re: **Geotechnical Response to City Review Comments**
Wateridge Residential Development
335 St. Laurent Boulevard - Ottawa

date: September 27, 2019

file: PG4064-MEMO.11

SECTION A-A
SCALE HOR. 1:250
VER. 1:100

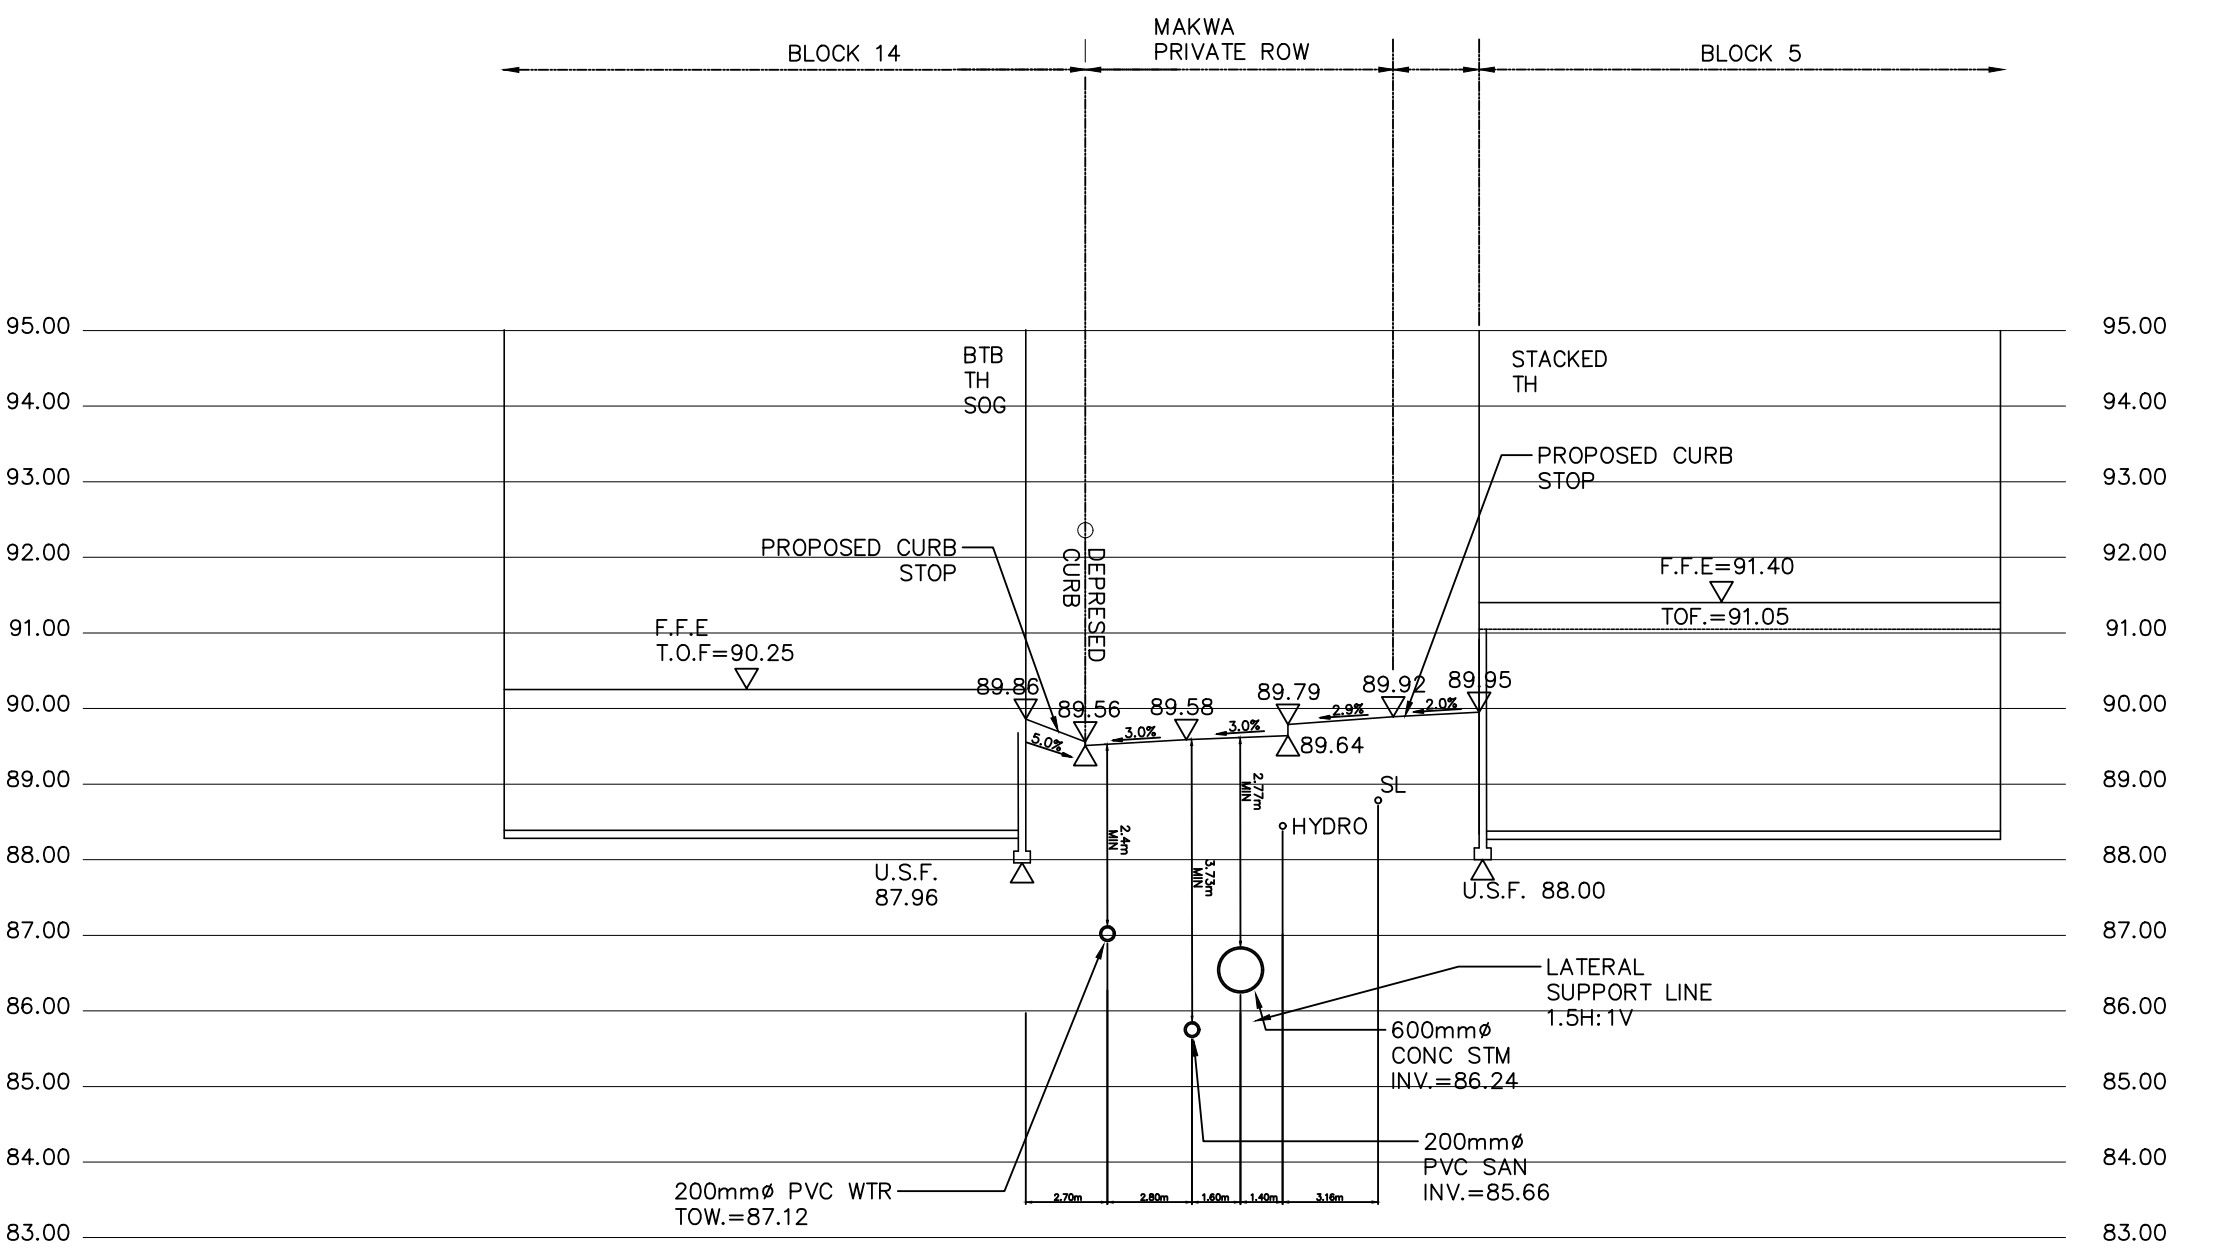
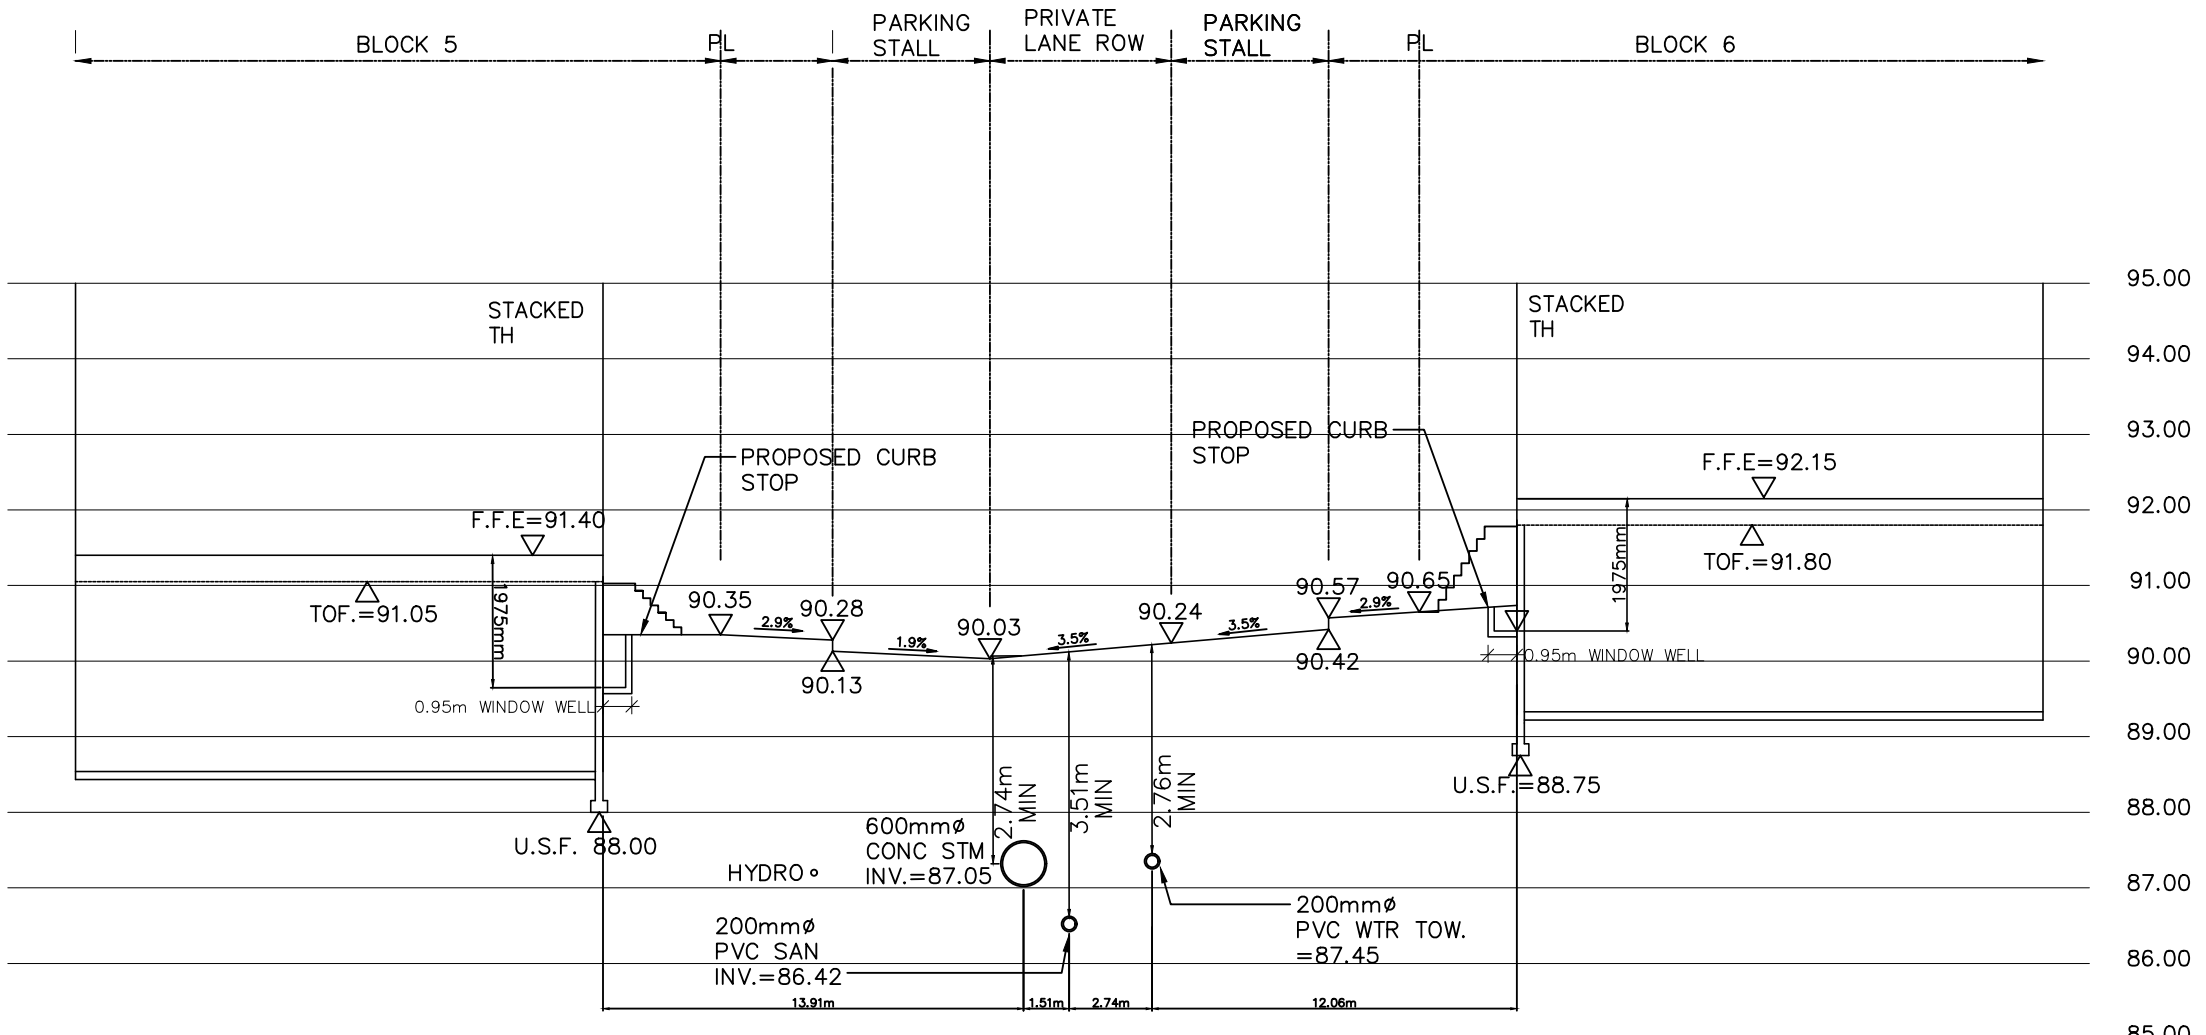
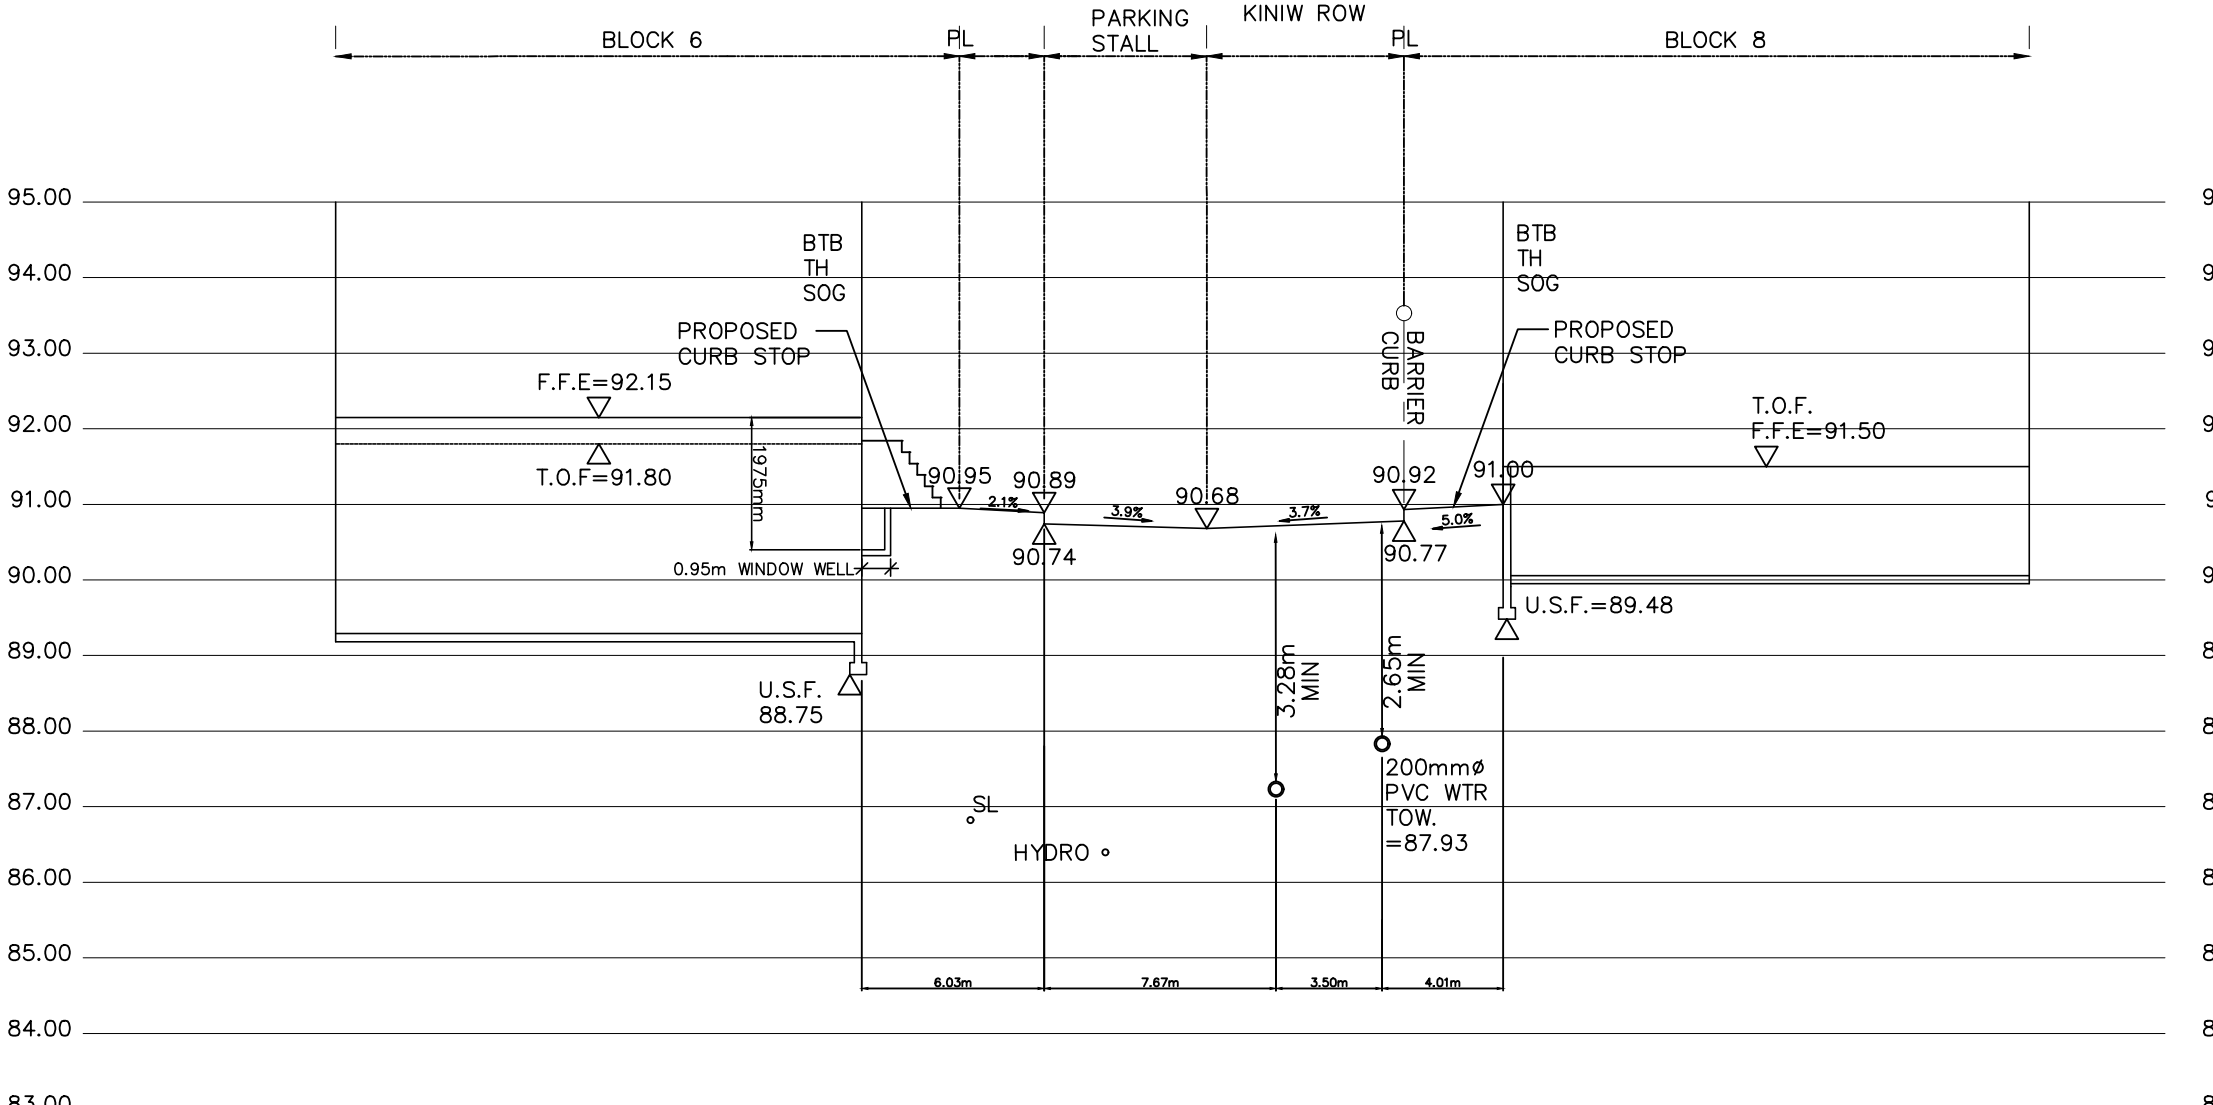
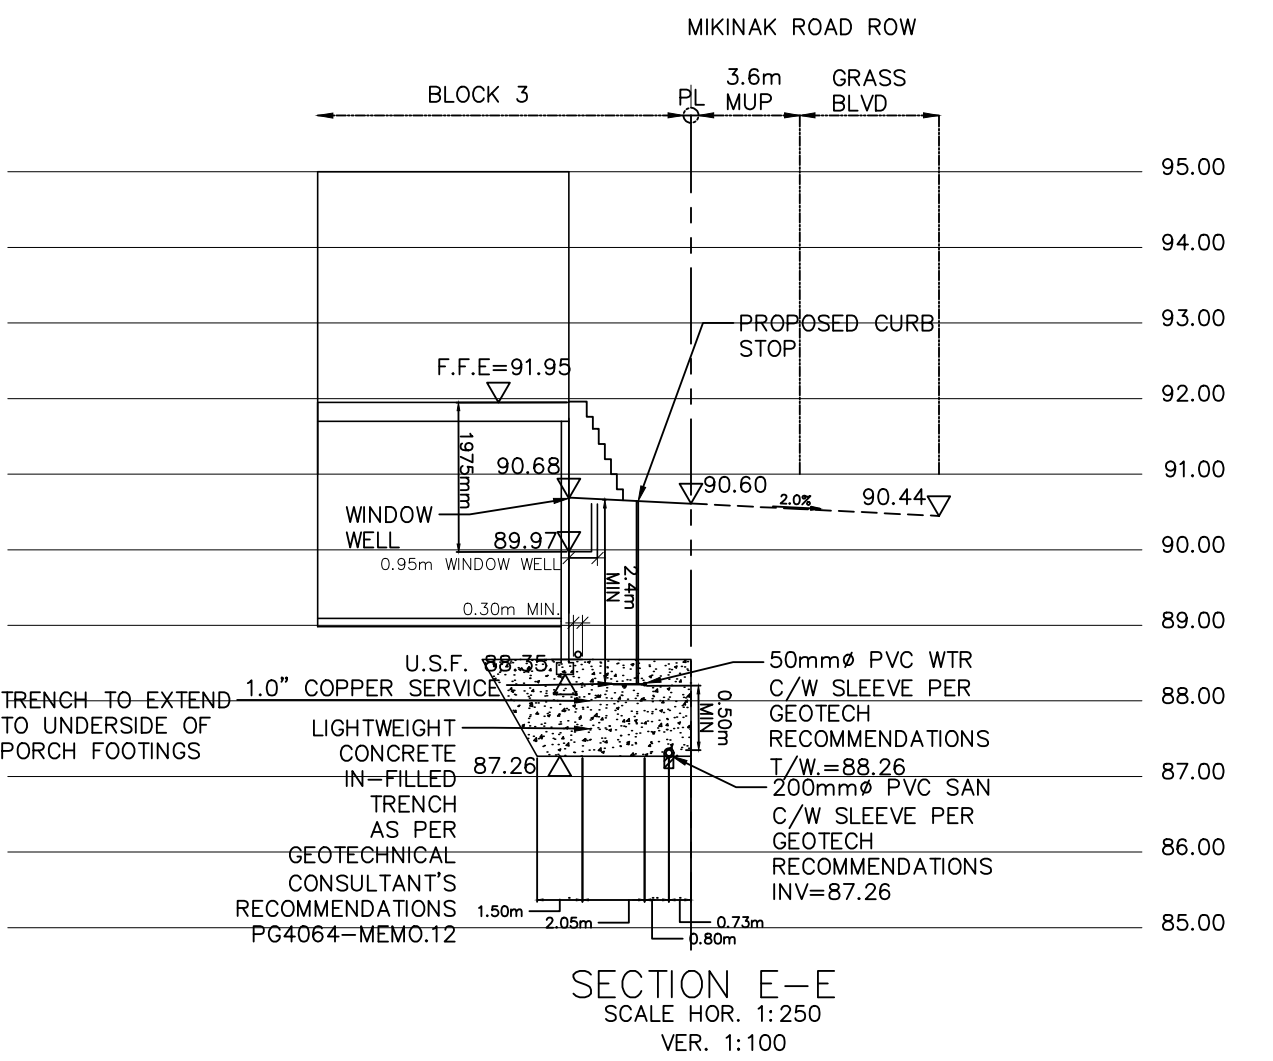
Comment: *The proposed private watermain and sanitary sewer along the north property line with a separation less than a horizontal separation distance of 2.5 m (edge of pipe to edge of pipe) is not supported. The reduced separation distance may be supported by Procedure F-6-1 however there appears to have been no consideration for future maintenance challenges as the sewer and watermain are located below the proposed underside of footings with minimal setback from the foundations. Repairing this private infrastructure without adversely impacting the structures and encroaching into the ROW will be difficult and unavoidable. Any maintenance costs will be significantly increased. Please investigate alternatives as any future repair costs will be the responsibility of the condominium corporation. Consideration shall be given to the future maintenance/repair challenges and associated costs with the servicing strategy and stormwater management solution proposals. Please demonstrate how this infrastructure would be serviced in the future for the City to review and provide recommendations from the geotechnical engineer. If these Blocks are to form part of the future condominium corporation the units shall be serviced internal to the development. Individual service connections under the current scenario to the public infrastructure within Mikinak Road would not be supported.*

Response: Reference should be made to PG4064-MEMO.12 - Lateral Support of Footings - September 26-2019 for information regarding the above noted comment. This memo should be read in conjunction with DSEL's drawings. This memo only addresses geotechnical aspects of footing/service lateral support. Impacts to ROW and additional costs to be addressed by Mattamy/DSEL.
